**1000, LLC**  
GBP LOT 12-2  
7190 COLE VIEW  
COLORADO SPRINGS, CO 80915  
EL PASO COUNTY, COLORADO

1 of 9  
SITE PLAN

# Markup Summary

5 DRIVEWAY DETAIL
NOT TO SCALE

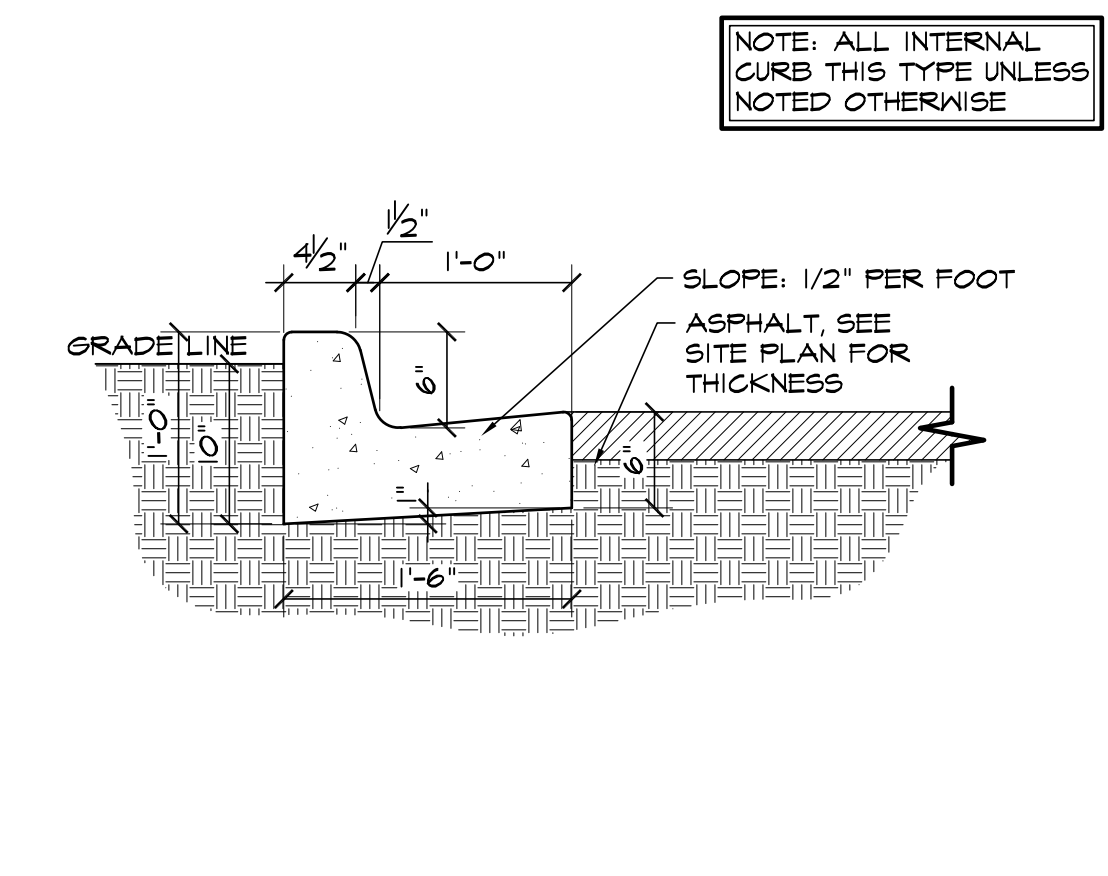
Replace with the County's standard driveway detail.
